30 November 2020

2190947

Response to Further Agency and Organisation Submissions Powerhouse Parramatta – SSD 10416

Post-development - River Flood  
Fixed Grill, FLC=0.4 & BLKG=25%  
Afflux  
1% AEP (540 min)

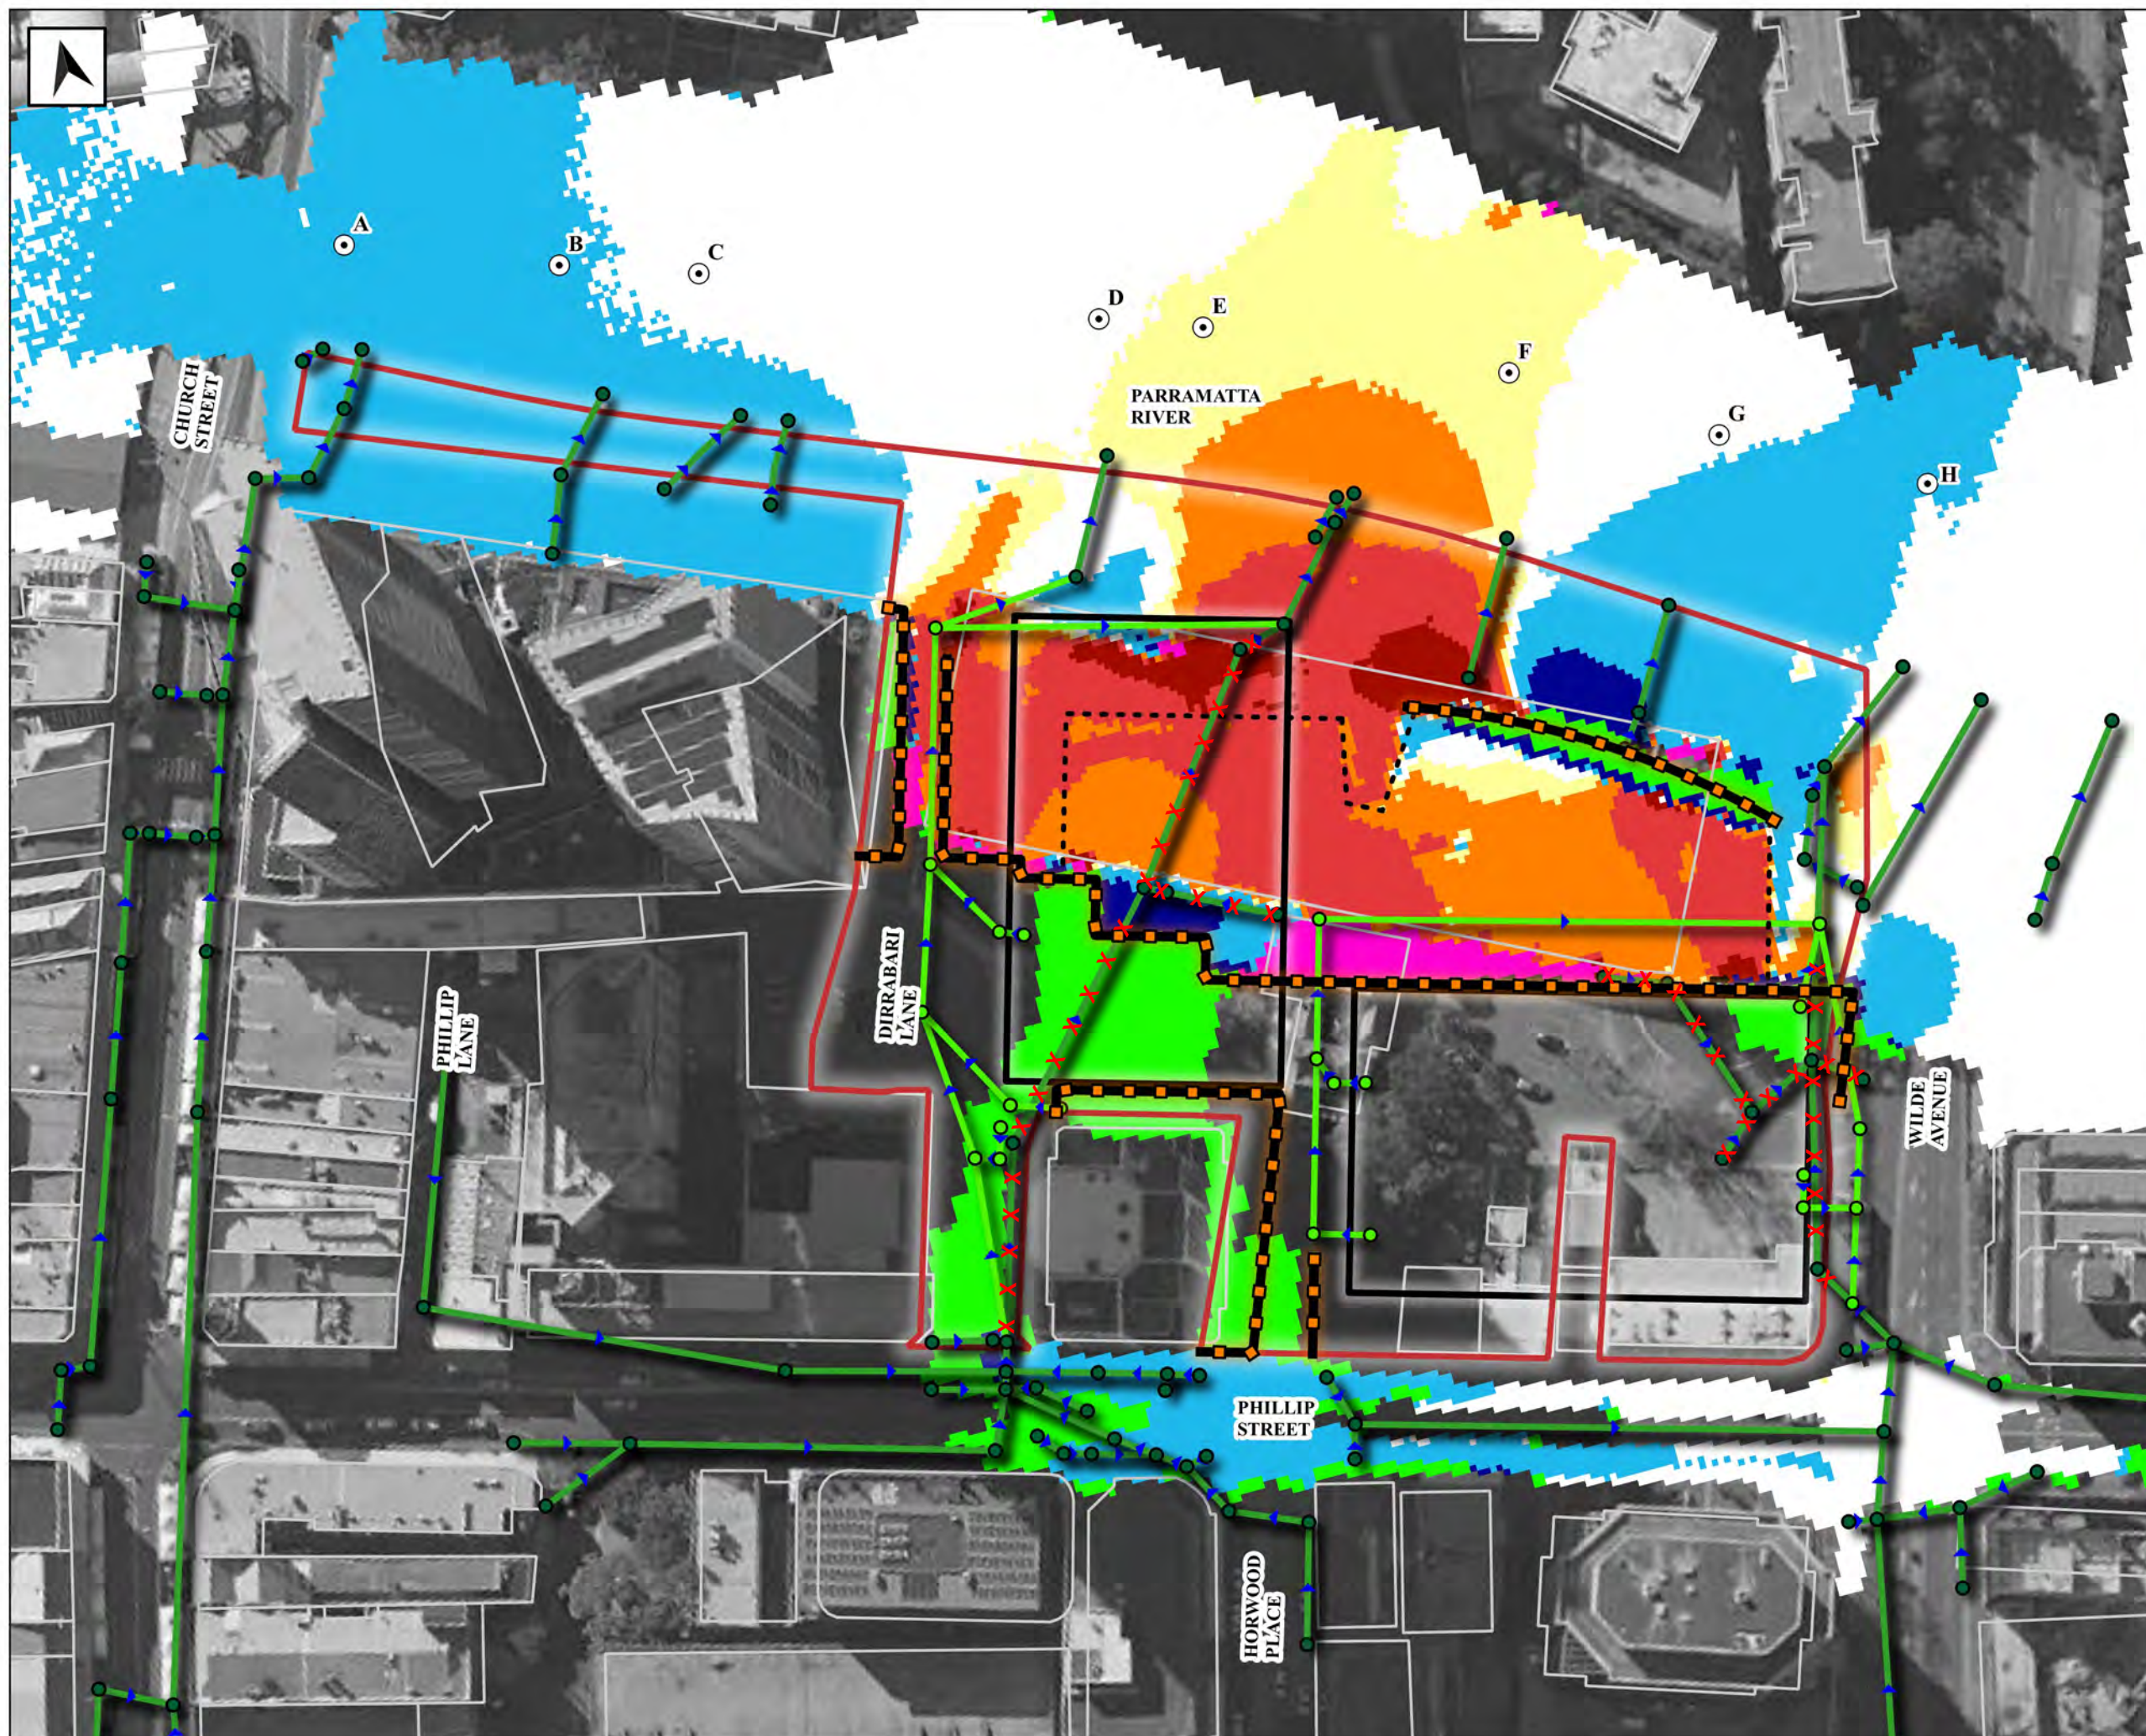
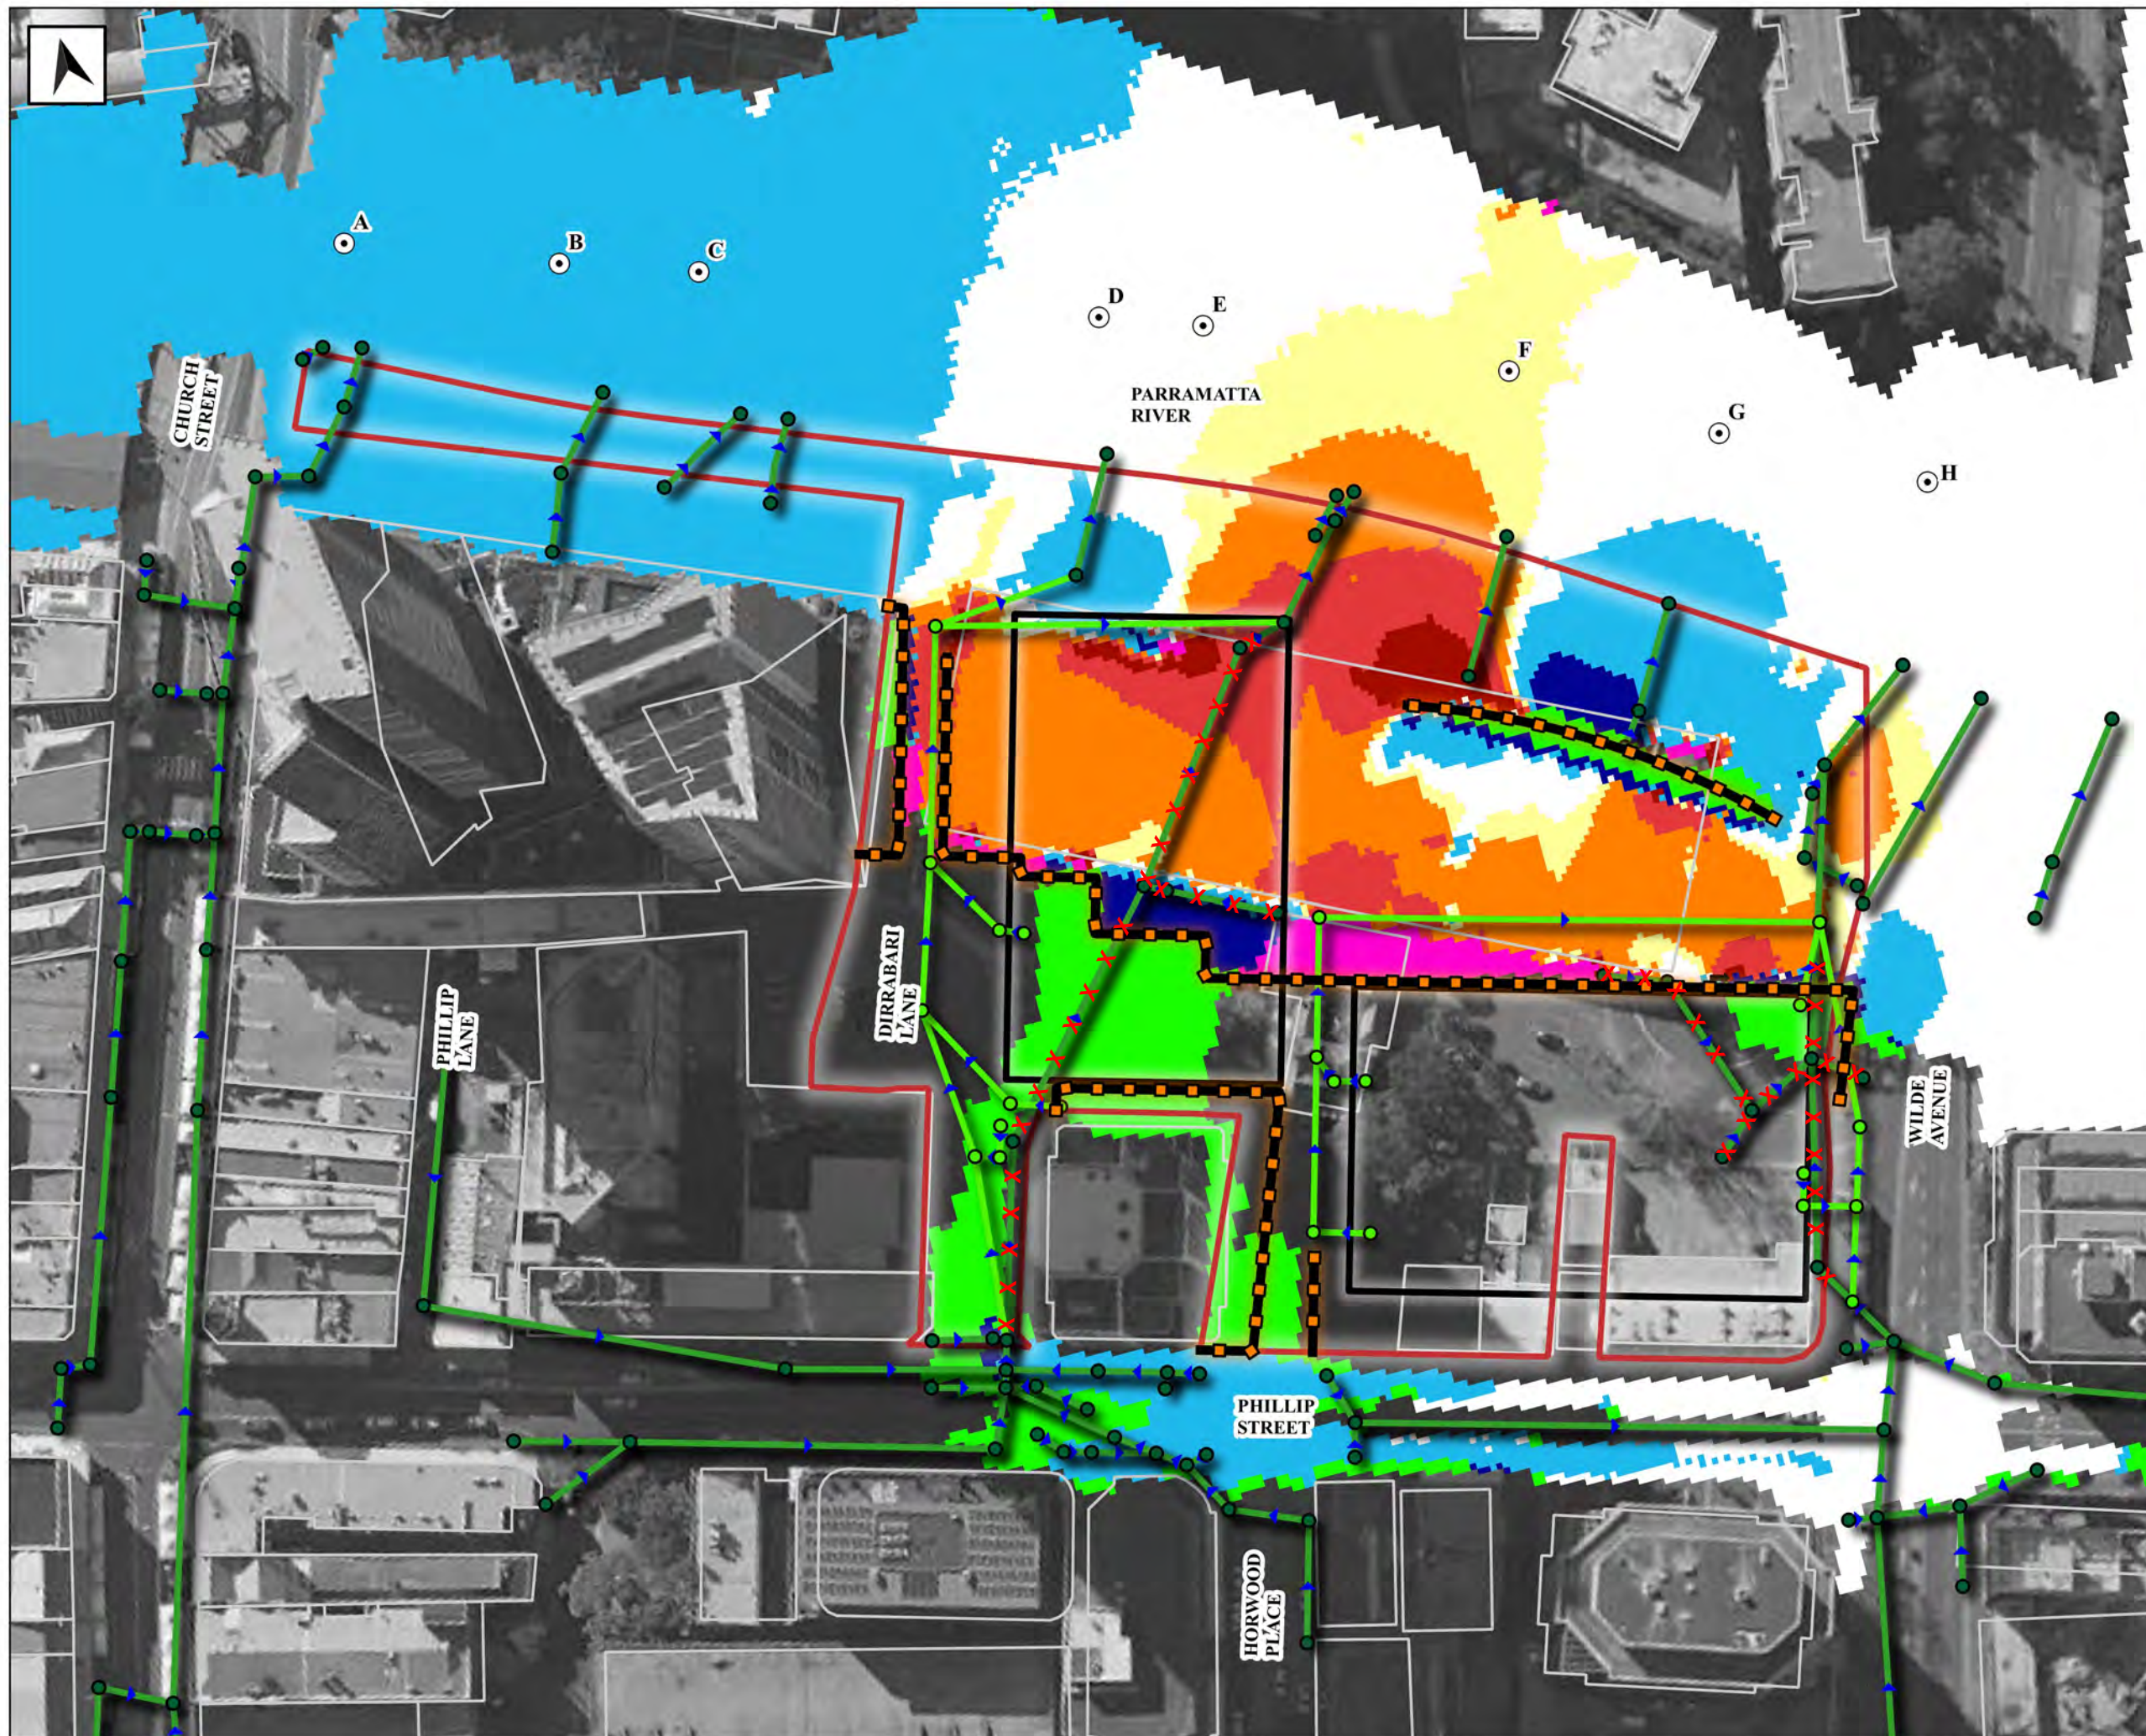
No.	Extract	Comment
CoP1	<p>Flooding and the Undercroft</p> <p>Council recognises the efforts made to modify the design to align with the Competition winning visualisation that showed a landscape solution that included a sloping embankment and a seamless relationship with the Parramatta River. Notwithstanding, the reality of the design is that the undercroft remains and the embankment serves to obscure it. The primary purpose of the undercroft is to convey floodwaters and at the same time provide additional habitable floor space for use by the Museum. Council maintains its view that the undercroft is not an appropriate solution for the site.</p> <p>In the Response to Submissions Report prepared by Ethos Urban on behalf of Infrastructure NSW dated 8 October 2020, it states that in response to concerns raised during the exhibition period, further detailed flood modelling was undertaken which confirmed that 'the proposed undercroft area is the best and only outcome for the site to mitigate and appropriately manage riverine flooding'. Council is contrary to this view.</p> <p>While Council acknowledges that the undercroft space will have limited access by the public through the erection of moveable screens managed by the Powerhouse, Council maintains its concerns regarding the suitability of the undercroft as a flood solution where the conveyance of floodwater through the undercroft also passes through proposed habitable floor space. This is due to the potential threat to life, property and critical building services in a flood event (including evacuation via a single, limited capacity lift, which provides critical access to mobility impaired). Council considers this to be in contradiction of the</p>	<p>As outlined in the Response to Submissions and accompanying Flood Risk and Stormwater Management Addendum Report, the Applicant maintains that there is no alternative to the inclusion of the undercroft whilst maintaining the architectural design of the museum. Adjustments have been made to the undercroft, in particular in relation to its use and management in response to Council's concerns, however, it is noted that contrary to this submission the undercroft is not considered to be habitable floor space. Flood modelling and advice confirms that the undercroft is a suitable flooding response.</p> <p>The Applicant maintains that the design and operation of the undercroft as well as the broader Powerhouse Parramatta proposal remains appropriate and safe from a flooding perspective. The concerns identified in Council's submission have been previously addressed in detail in the Response to Submissions and accompanying Flood Risk and Stormwater Management Addendum Report, and the responses in these documents should be referred to.</p>

No.	Extract	Comment
	<p>Floodplain Development Manual and NSW Flood Policy. This space will have a level floor and the 1% AEP (100 year) floodwaters will flow with substantial velocity 2-3m deep extending to the back wall of this structure.</p> <p>It is Council's view that there are alternative solutions, including a design that delivers an alternative means of achieving floodwater conveyance along the river through an appropriately designed landscaped riverbank. There are other reaches of the river nearby with similar river flow, river width and which have cross sections that contain this 1% (100 year) flow within the boundaries. These typically have sloping banks that enable people to safely find their way to higher ground out of the river corridor as floodwaters rise.</p> <p>In this regard, Council reiterates its earlier recommendation that the undercroft be removed from the design. It also recommends the undercroft be replaced with a suitable sloping riverbank section that may be a viable solution to manage the conveyance of floodwater. This would also have the added benefit of creating a more integrated foreshore landscape interface where the 'natural' sloping riverbank profiles that existed before the existing car park was originally constructed (and which appear to be still visible on site) could be considered as the baseline for predevelopment conveyance capacity and afflux considerations.</p> <p>In relation to overland flow, once riverine flooding and conveyance has been resolved safely - by changing the built form and surrounding landform, it will also be necessary to re-examine the overland flow pathways across the site and how these affect useability, public safety and risk management.</p>

AU3	<p>Following review of the RTS, Australian Unity remain concerned regarding the overland flooding considerations.</p> <p>The existing 600mm diameter pipe which currently runs under Dirribarri Lane and the multideck carpark will be replaced by a 1200mm diameter pipe running under Dirribarri Lane and heading directly north to the river. On the eastern side</p>	<p>It is noted that the advice provided by Molino Stewart is not made in relation to the documentation provided with the Response to Submissions. The matters raised within this submission are adequately dealt with in Appendix J of the Response to Submissions Report.</p>

No.	Extract	Comment
	<p>of the subject site a new 600mm pipe will be laid to take water directly to the river between the two museum buildings.</p> <p>Molino Stewart have raised concerns with the flood modelling prepared by Arup at Appendix O of the EIS. In particular, concerns are raised in relation to whether adequate consideration has been given to the potential blockage of stormwater pits. Blockage in stormwater pits has the potential to change the reported flood modelling results.</p> <p>It is noted that City of Parramatta Council requires an assumption of a 100% blockage factor for any flood modelling associated with development applications in the CBD. This assumed blockage percentage will have a significant bearing on whether the proposed development will increase or decrease flood levels at the subject site.</p> <p>The existing stormwater flows pond in front of the subject site and flow in a 600mm diameter pipe under the Dirrabirri Lane to the river. When the flows to the low point exceed the capacity of the pipe the water rises until it reaches the high point in Dirrabirri Lane and the high point in Willow Grove and flows overland around the subject site.</p> <p>If the inlet to the 600mm diameter pipe is partially blocked, less water will get into the pipe and more water will have to flow overland to the river in the same storm event. This means that any blockage in the pipe will increase the depth of the flows around the subject site and the depth of ponding in front of the building. A 100% blockage will mean all the flows go overland and maximise the flood depths at the subject site.</p> <p>The overland flow management strategy for the PPM is to increase the capacity of the pipe in Dirrabirri Lane and to provide a new pipe to take overland flows along the eastern side of the subject site. This will effectively increase the flow rate underground and reduce the flow rate overland. Molino Stewart are concerned that if the inlets to the pipes are 100% blocked then they will make no contribution to flood conveyance and will not reduce flood levels at the subject site. As it is proposed to increase the ground levels to the east of the subject site and if Dirrabirri Lane is increased in level, then overland flow water will need to pond to a higher level in Phillip Street and increase the flood levels for the subject site.</p> <p>Requested Actions:</p> <p>3a) Australia Unity support the provision of amplified stormwater pipes on either side of 32 Phillip Street site.</p> <p>3b) The flood impacts of the final PPM design should be tested using City of Parramatta Council's more up to date, and peer reviewed, flood model when it becomes available to ensure that there will be no adverse flood impacts on the subject site or the surrounding public domain.</p>

No.	Extract	Comment
	<p>3c) The PPM project team should be requested to provide updated flood modelling accounting for an appropriate blockage percentage for stormwater pits.</p> <p>3d) The civil design solution must not increase flood levels adjacent to 32 Phillip Street.</p>
